Subject: FW: Norton Farm House compliance 1

Subject: AL/35/21/DOC - Norton Farm House - CONSULTATION

Just to confirm consultation requests have been sent to you all, regarding DOC condition 5 – hard landscaping (relates to a listed building/conservation area and Lidsey Drainage Area).

DRAWING TITLE
EXTERNAL WORKS

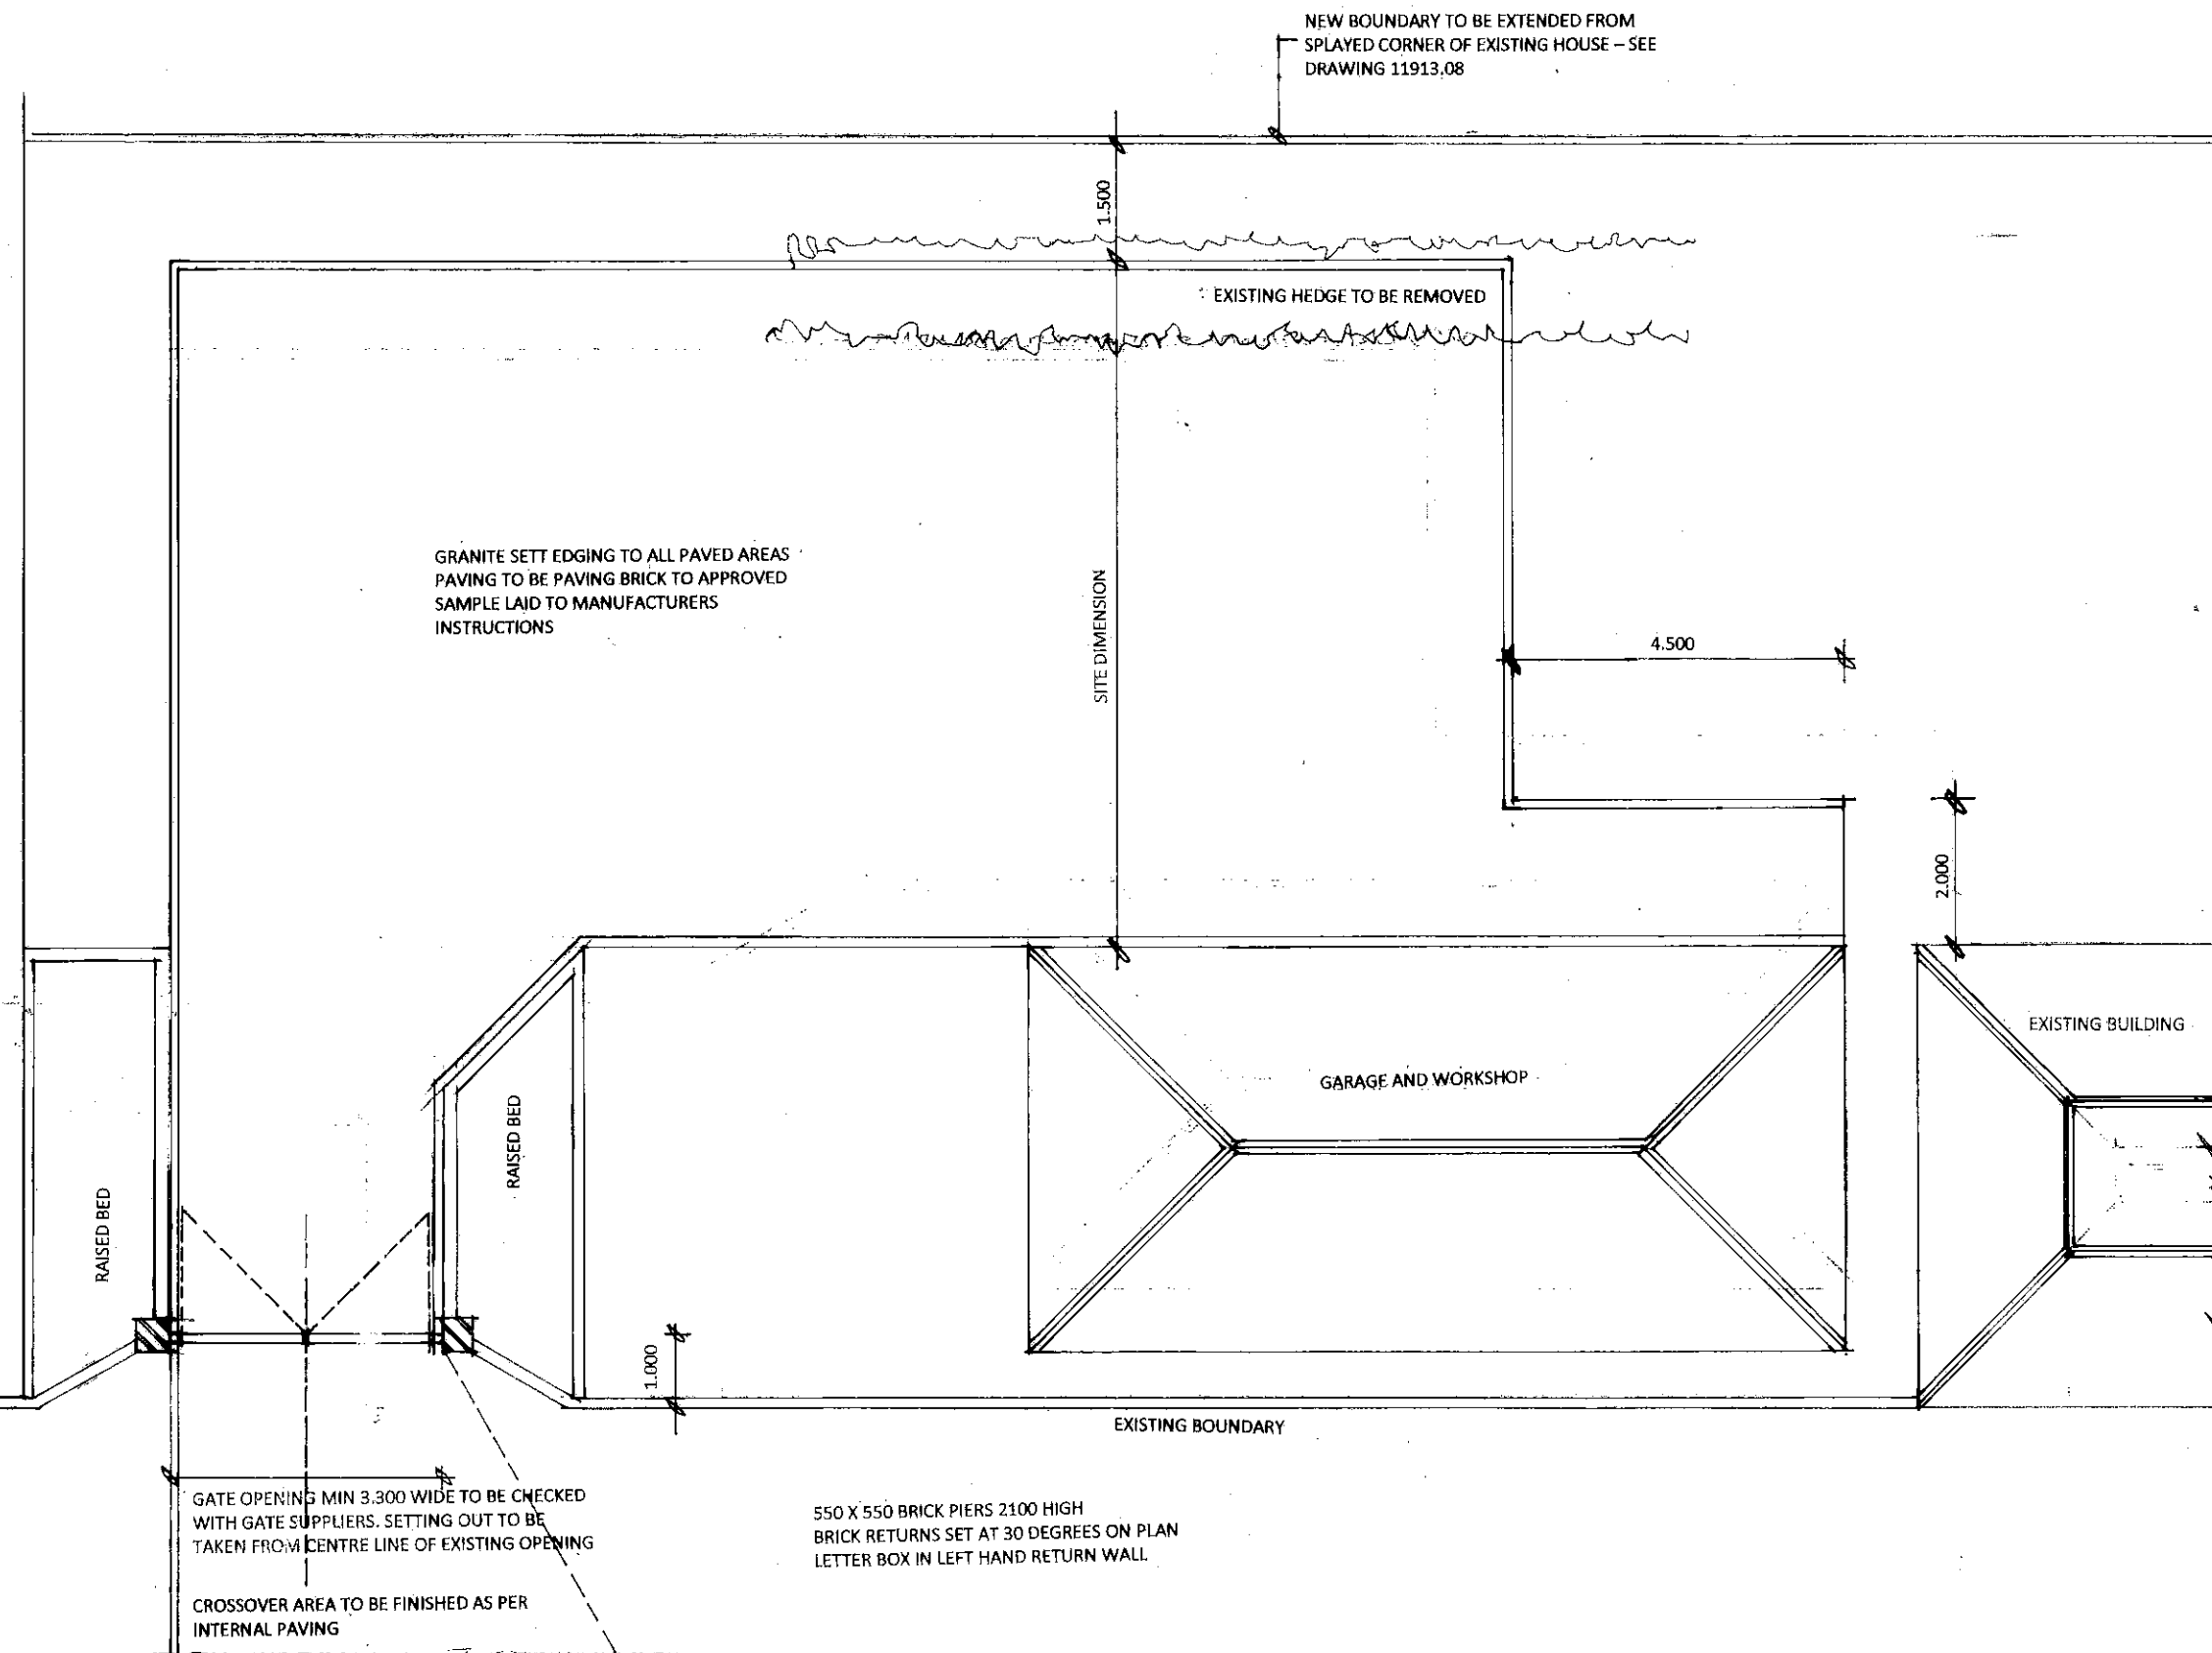
The application AL/35/21/DOC contains no soft landscape detail and neither did the AL/34/20/PL application (no landscape consultation sought)

Generally for a replacement building to same footprint, there would potentially be little or no need for landscaping unless changing the overall impact of the proposal in its setting. If landscaping were to be incorporated I would suggest this be to the south of the development into the verge area, (assuming this is under the curtilage of Norton Farm House) which has already been formed into a planting area, albeit somewhat sparse. Planting into this area could help to soften the impact of the new construction along Old Dairy Lane (advisory)

In this case even though the plan states *tree and scrub to be removed* this is beyond the footprint of the proposals. There was no landscape addition shown or proposed with this development. The hard landscaping I will leave to the Conservation Officer as to suitability in connection with Listed Building and Conservation area constraints. The paving is shown as permeable which is preferable to an entirely hard surface finish such as Tarmac.

I confirm that I would have no landscape objection to the proposals (just advisory as above) compliant or not.
